Ribble Valley Borough Council

App no: 3.2026.0230

Address: Land to the south of Ribblesdale Primary School west and north of Higher Standen Drive, Clitheroe

Proposal: The erection of 60 dwellings comprising houses, bungalows, flats, related infrastructure (including public open space) and landscaping.

Drawing No.	25-166-P01	Rev.	A
Scale:	1:500		
Date:	Jan 26		
Sheet Size:	A1

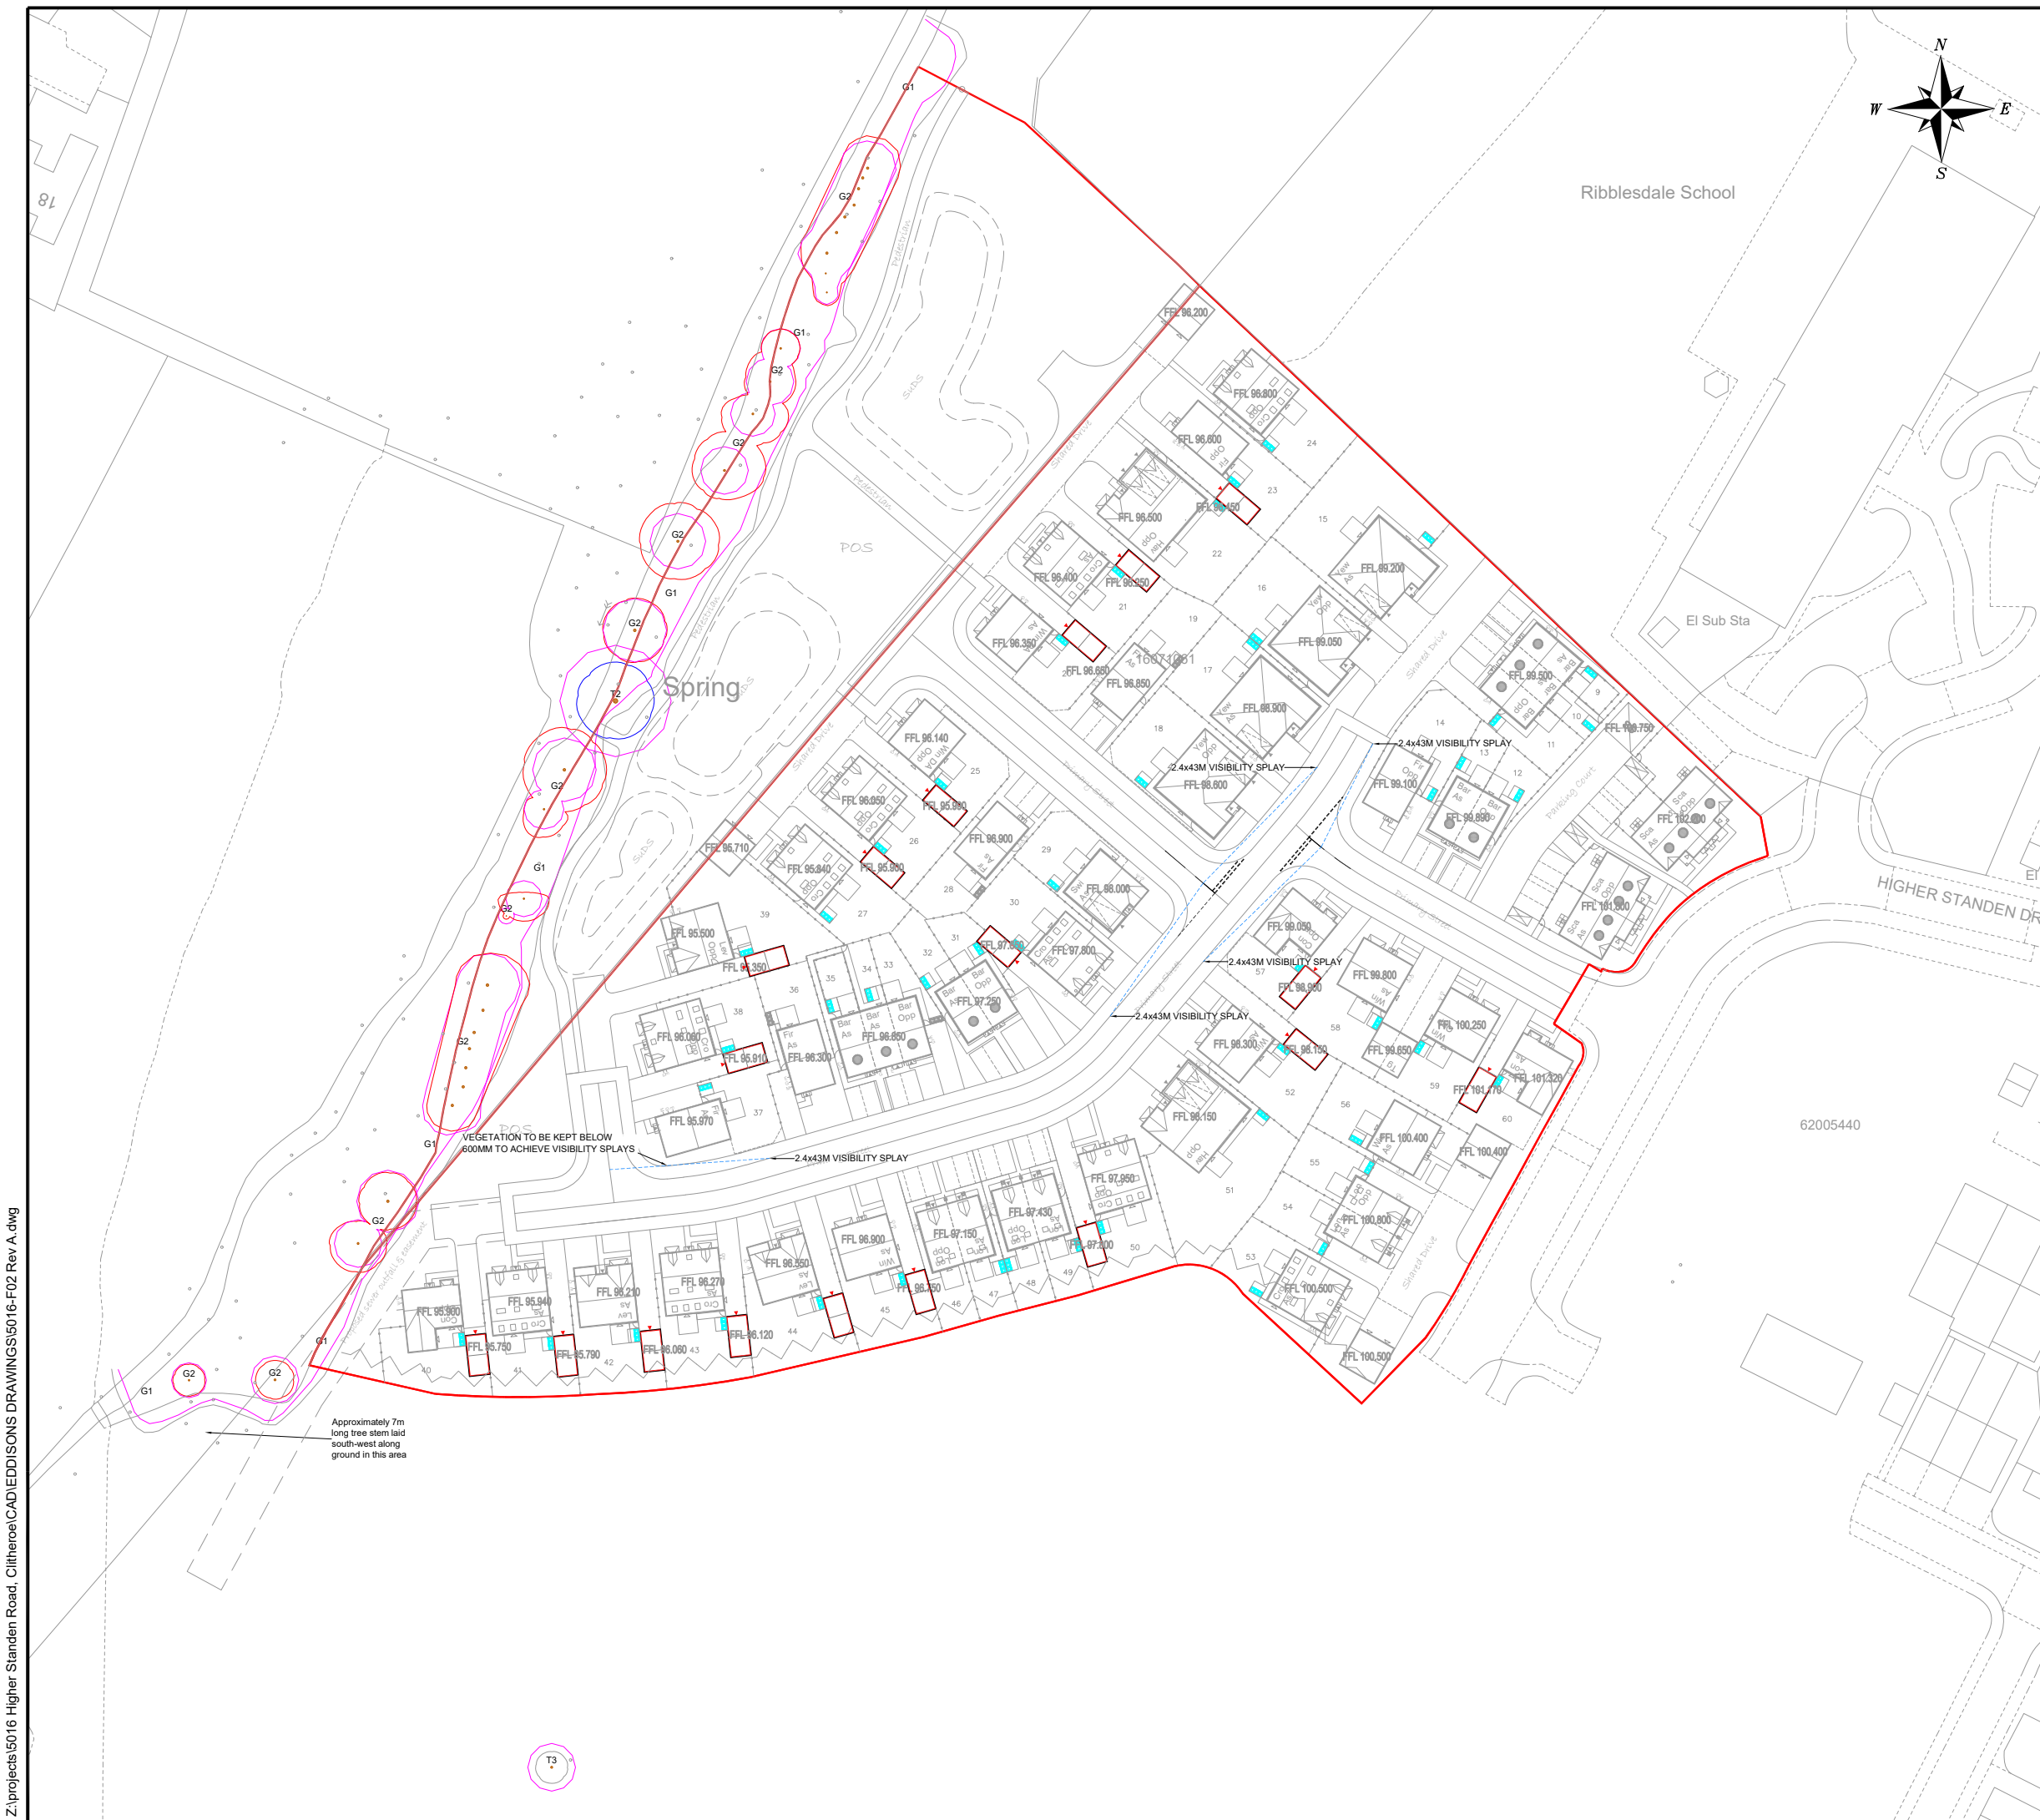
A potential pedestrian link is indicated on the internal layout in the most northern point. Upon visiting site, it is evident that this is an existing well walked desire line for pedestrians to access public footpath FP0301014. The extract from the map below shows the existing route highlighted orange (currently grass/field) which is required to be retained both across the site and connecting to the north and south to the existing formalised path provision. The proposed link should be widened 3m wide to allow a shared cycle/footpath provision and surfaced to match the existing provision on the Taylor Wimpey wider site.

There should be a pedestrian/cycle connection to the southwest corner of the site near plot 40.

We would request that Phase 5/6 proposed plot layout (application 3.2022.0317) is included on the layout to show how links tie into the adjoining development.

Each plot has a driveway for 1 or 2 cars and certain larger plots have a garage measuring 3m by 6m internally. Each plot without a garage must have a secure and covered cycle store for at least 2 bicycles.

PLAN 4

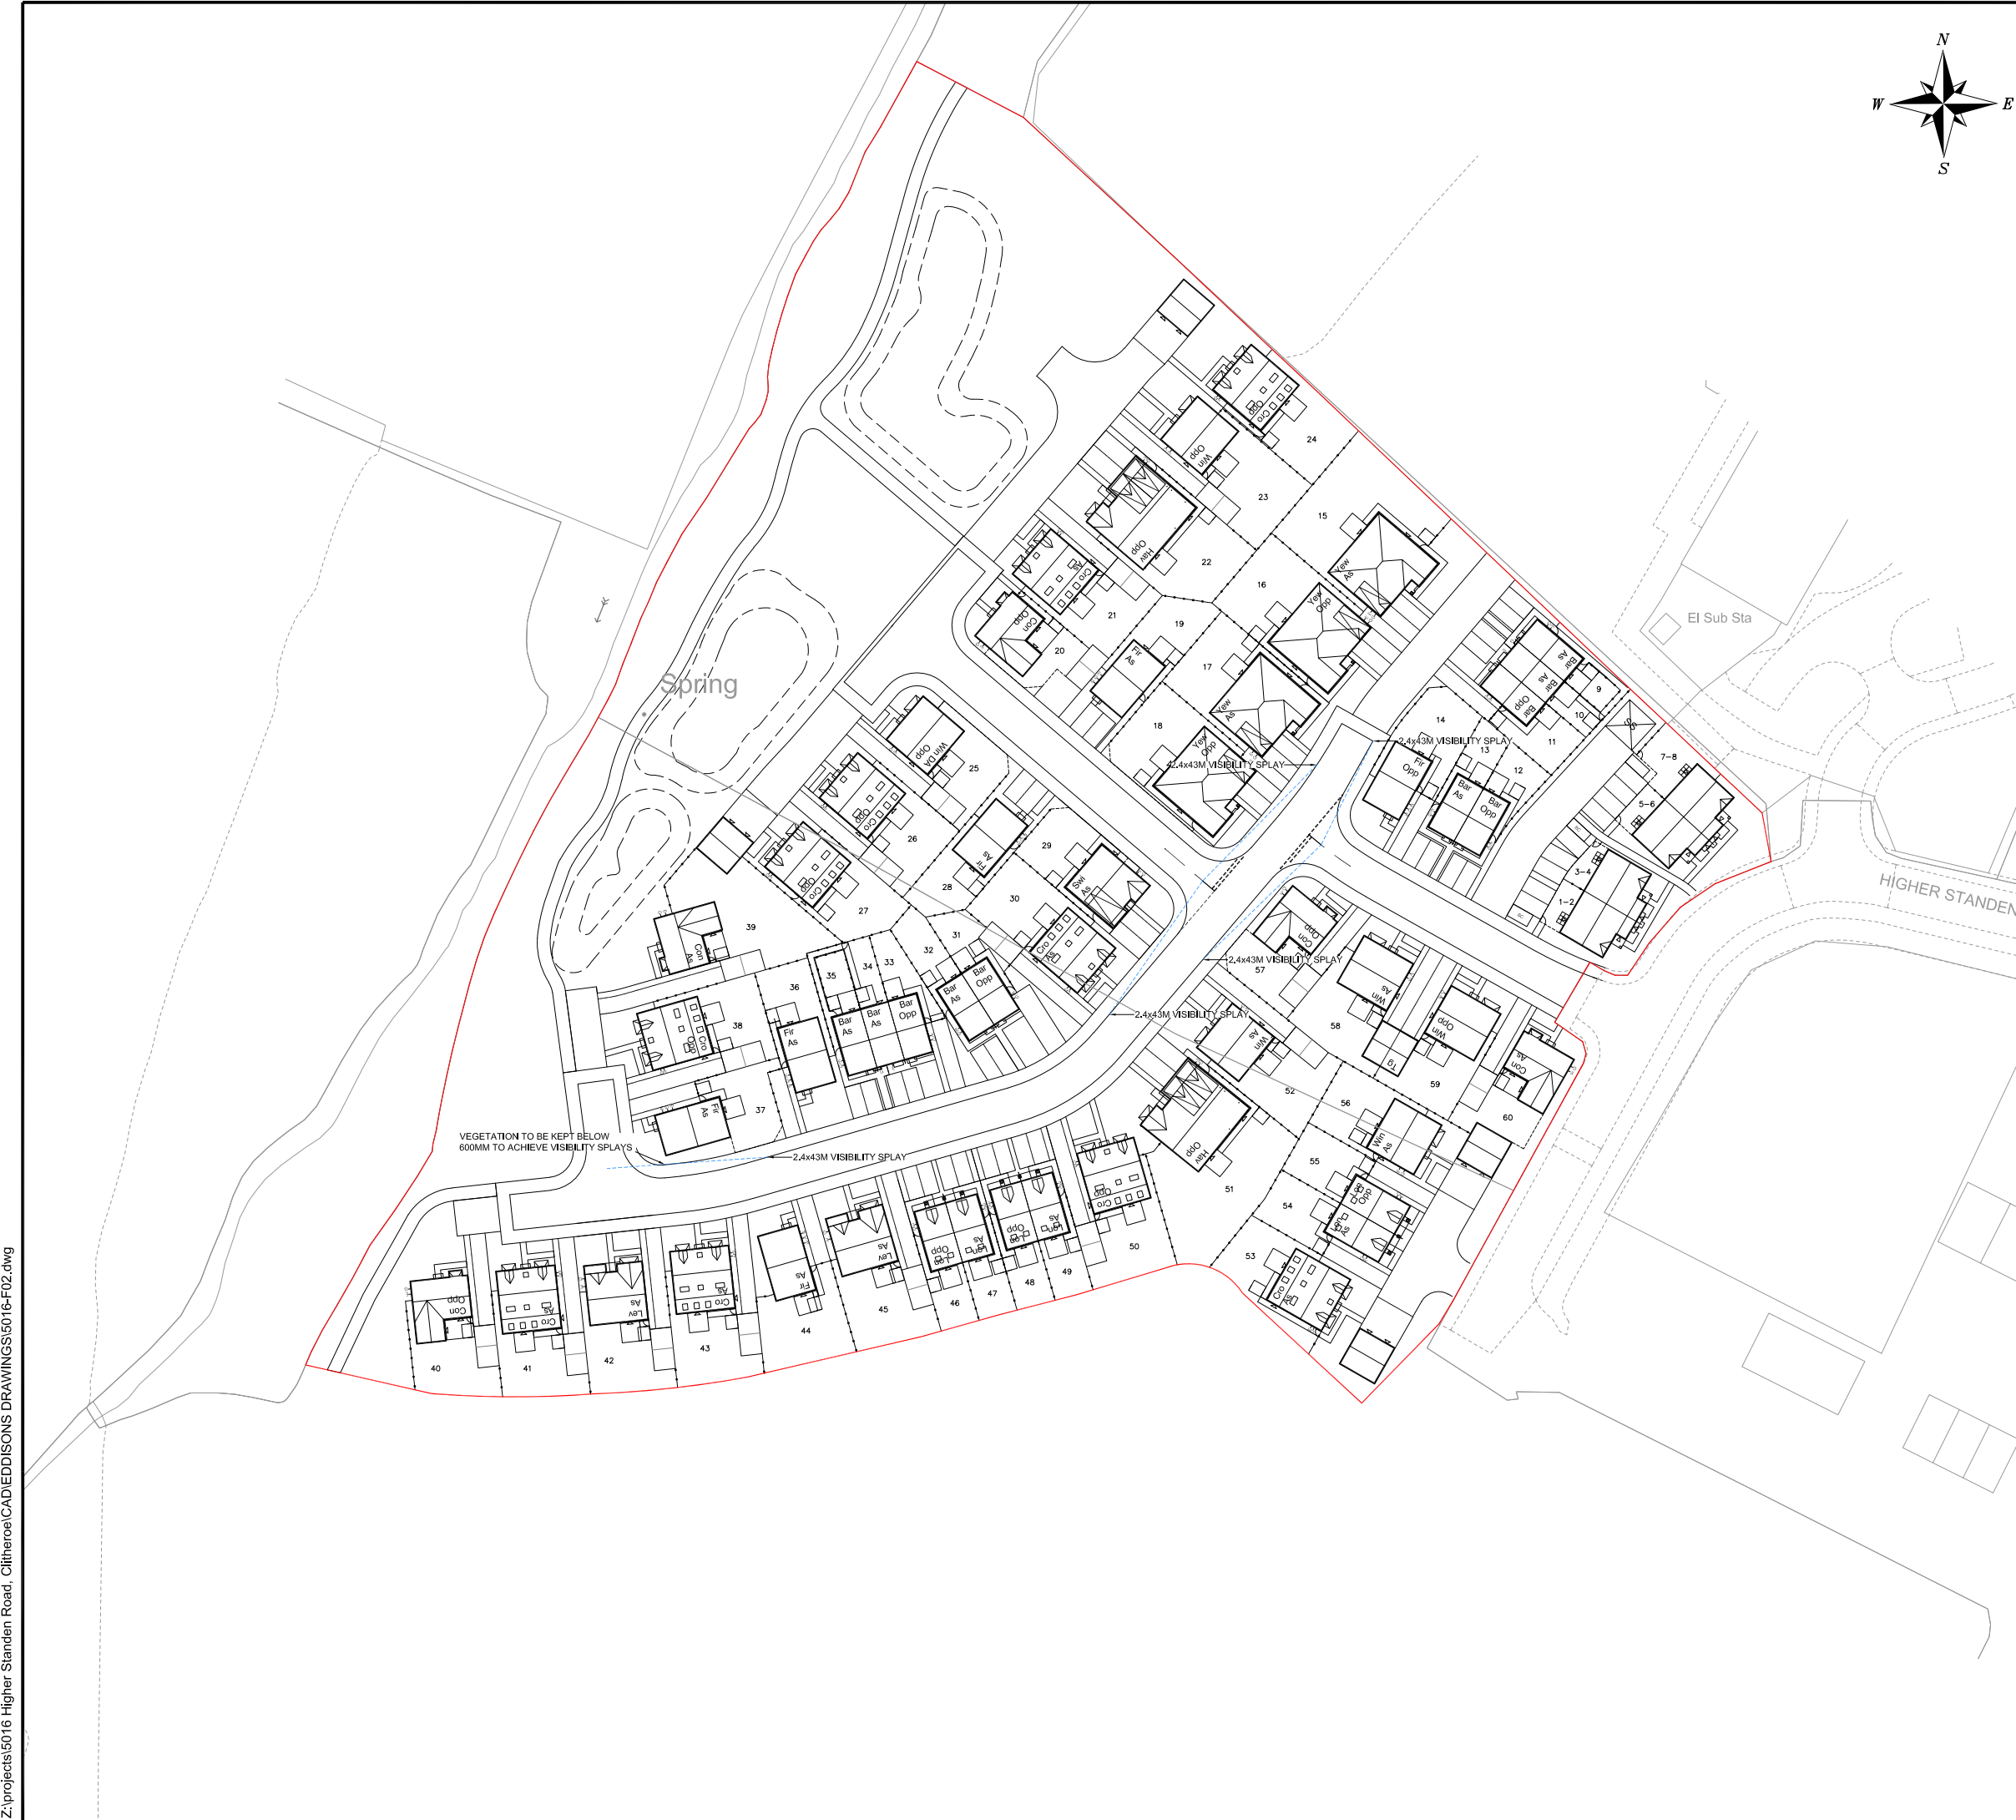
Visibility splays of 2.4m by 25m to both sides are shown on a drawing in the Transport Statement, the splays will lie in land proposed to be highway. The splays need to be extended to 2.4m by 43m to both sides as Higher Standen Drive is anticipated to be subject to a 30mph speed limit.

There is a private driveway proposed onto the spine road to serve plots 53-56. Splays for this site access are required to be submitted at 2.4m by 43m.
